DECISION DELEGATED TO HEAD OF PLANNING

Application No: H20-0417-25 **Applicant:** Mr Coupe & Miss Roberts

Proposal: Demolition of conservatory & erection of single storey front & side extensions

Location: Markenville 17 Broadgate Road Sutton St James

PROJECT: PROPOSED SINGLE STOREY SIDE/FRONT EXTENSIONS	
DRAWING: EXISTING FLOOR PLAN EXISTING ELEVATIONS	
SIZE: A1	CLIENT: Mr A. Coupe & Miss Z. Roberts
SCALE: as labelled	DRAWING BY: JC
DATE: 31/03/2025	SHEET: 0479/25/01

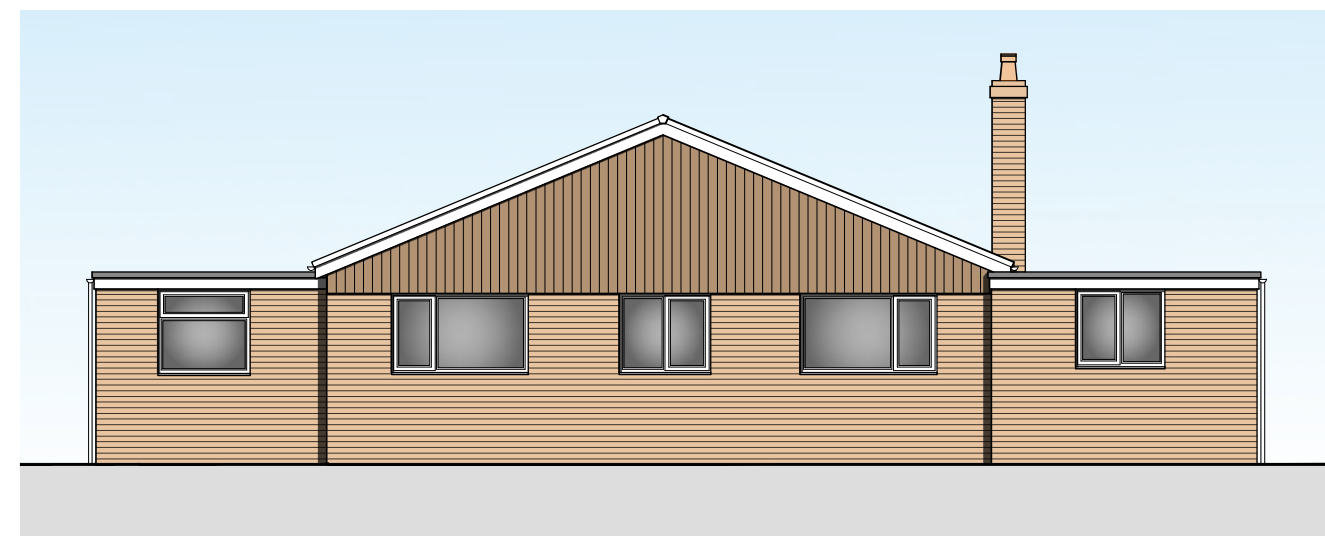
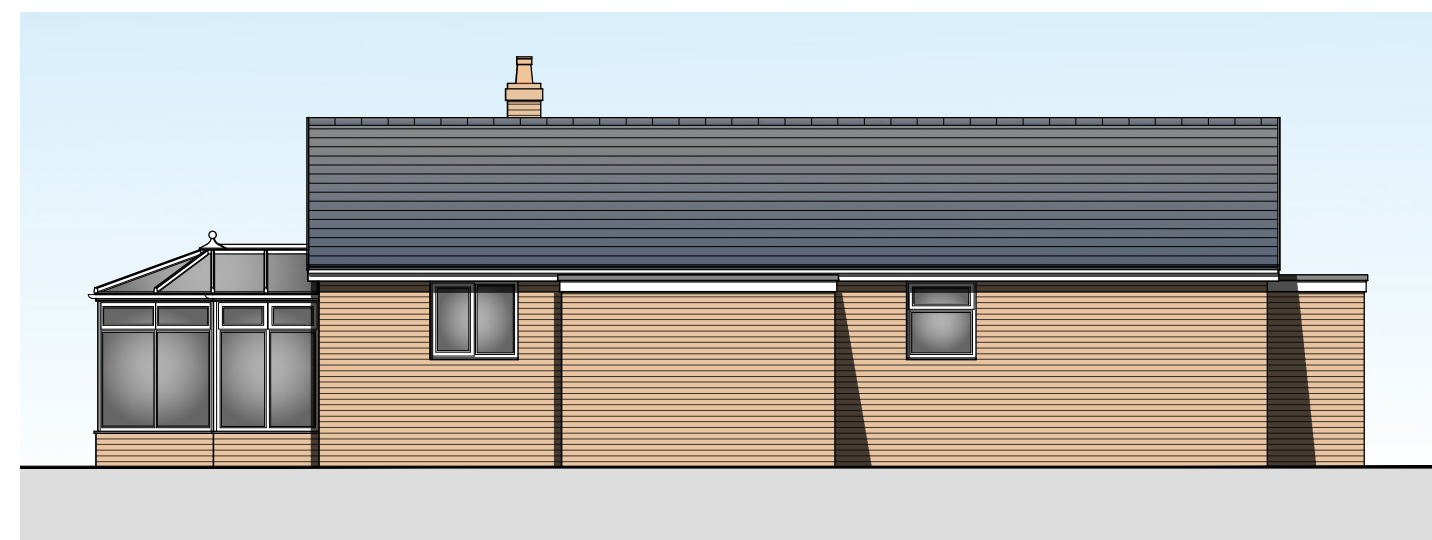
The existing dwelling comprises a detached single storey bungalow. The dwelling features a gable end roof form within its middle section, and two side extensions that both feature flat roof forms. There is an existing boundary wall in front of the southern side extension which screens the lower part of the extension from view along the street scene. This wall is not shown within the submitted plans.

PROJECT: PROPOSED SINGLE STOREY SIDE/FRONT EXTENSIONS	
DRAWING: PROPOSED FLOOR PLAN PROPOSED ELEVATIONS	
SIZE: A1	CLIENT: Mr A. Coupe & Miss Z. Roberts
SCALE: as labelled	DRAWING BY: JC
SHEET: 0479/25/02A

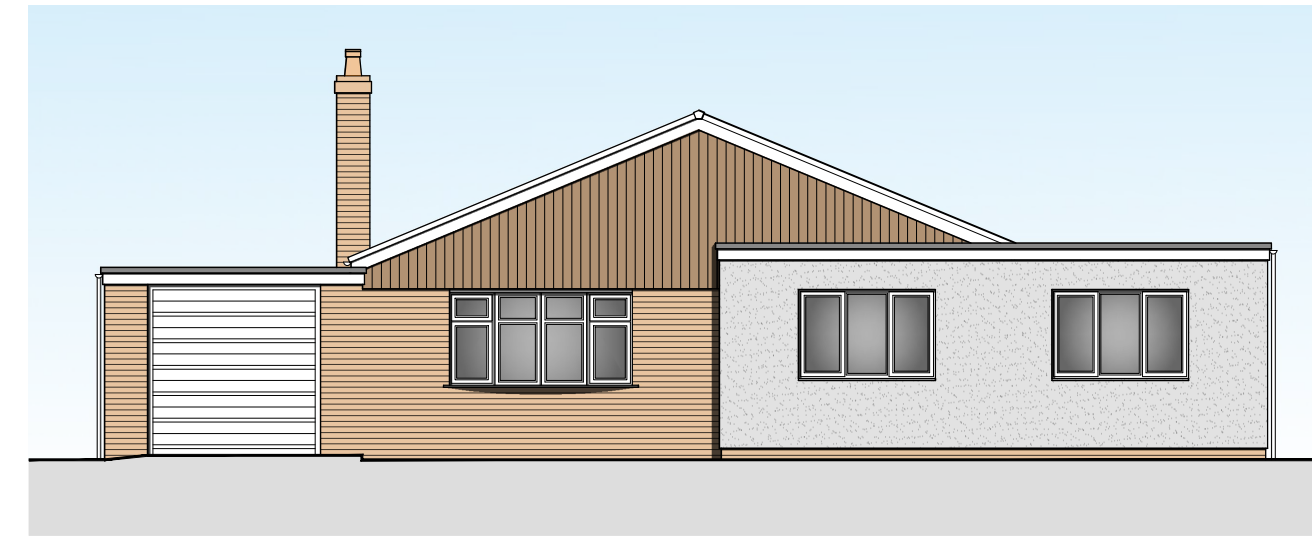
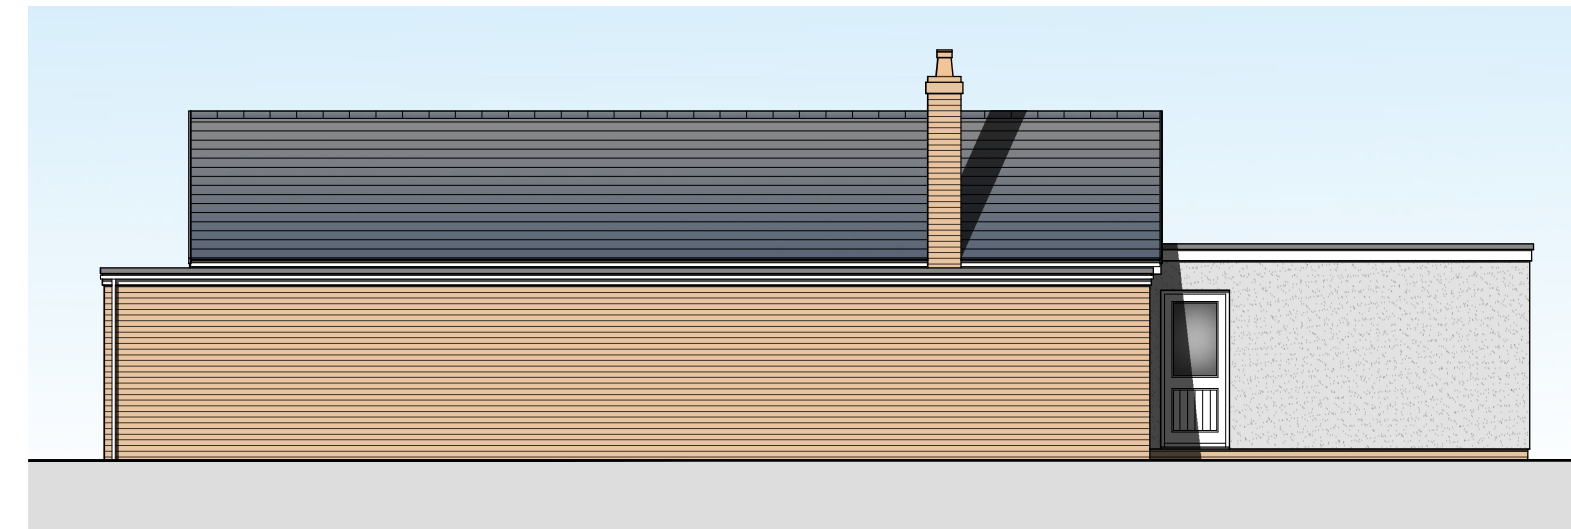
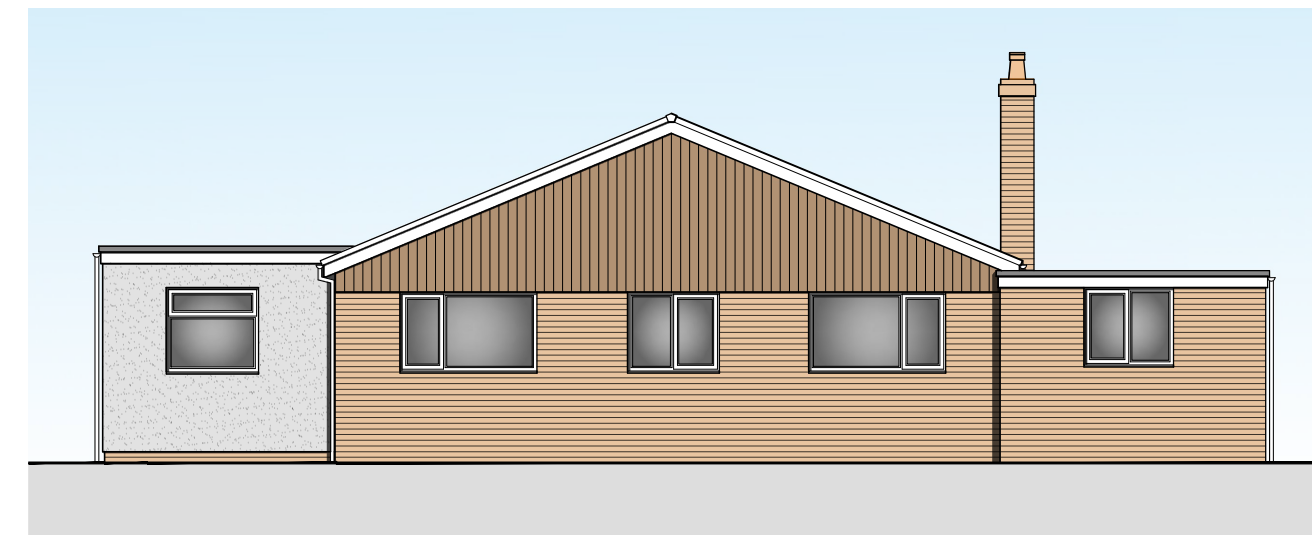
One of the extensions is proposed to be located on the south-western corner of the dwelling. The proposal seeks to extend the existing flat roof side extension and project this in front of the dwelling, replacing the existing conservatory. The conservatory measures approximately 3m by 3.1m and features a hipped roof form measuring 2.9 in height. The conservatory features approximately 0.5m of brickwork and windows on the upper parts of the structure.

The extension would measure 5m in length from the front elevation of the dwelling, and 8.2m from the existing utility room which is where the existing side extension is located. The extension is proposed to measure 7.2m in width. The extension would be taller than the existing extension, projecting above the eaves of the main dwelling. For reference, the proposed extension would measure 2.8m in height compared to the existing extension which measures 2.5m in height. The proposed extension would therefore be larger than the existing conservatory and would introduce more built form at the front of the site. Furthermore, the main dwelling features grey brickwork facades and timber cladding on the upper part of the front elevation, whereas the extension is proposed to feature light grey render.

The extension would result in the built form moving closer to the road frontage than the existing dwelling. Whilst there is no strict uniformity in terms of surrounding plot layouts, the nearest dwellings (15 and 19 Broadgate) are set back from the road frontage at a similar distance as the existing dwelling. The introduction of more built form in front of the dwelling would therefore diverge from the nearest dwellings. Furthermore, the existing side extension is partially screened by a boundary wall. The wall helps to reduce the visual impact of the extension which is not considered to be an attractive element of the dwelling. The proposal would result in the removal of this wall, making the new extension much more visually prominent within the street scene.

It is considered that the siting, scale and appearance of the extension would result in a harmful impact on the street scene. The contrasting materials combined with the height of the extension, which would extend above the eaves of the main dwelling, would result in an incongruent form of development. Whilst there is an existing conservatory on the front of the dwelling, this conservatory is considered to be a subservient addition, and the materials match the main dwelling. In contrast, the extension would result in a disproportionate addition that would result in an incongruent form of development that negatively harms the character and appearance of the area.

The other extension is proposed on the northern side elevation. There is an existing side extension located towards the rear of the dwelling. The existing extension measures approximately 3.4m in width and 5.8m in length. The proposal seeks to add an extension in front of this, measuring 7.9m in length. The existing extension features a flat roof form, and the proposed extension also features a flat roof form. The extension would also project above the eaves of the main dwelling, measuring 2.8m in height. This is considered to be unsuitable for the reasons set out previously. The submitted plans appear to show brickwork on the northern side extension, however, the agent has clarified that render is proposed and this is indicated on the submitted application form. As with the other proposed extension, the proposed rendered facades would exacerbate the visual harm of the proposal.

The proposed extensions are considered to comprise poor design that would negatively impact the character and appearance of the area. The visual impact of the development would be unacceptable and as such the development does not accord with Policies 2 and 3 of the Local Plan, or Section 12 of the NPPF.

The nearest dwellings to the site include 15 Broadgate to the north-east, and 19 Broadgate to the south-west. The proposed extensions are not expected to result in an unacceptable degree of overlooking with either neighbouring dwelling. For example, no additional windows are proposed on the side elevations other than a bathroom window. Provided obscure glazing is used for the
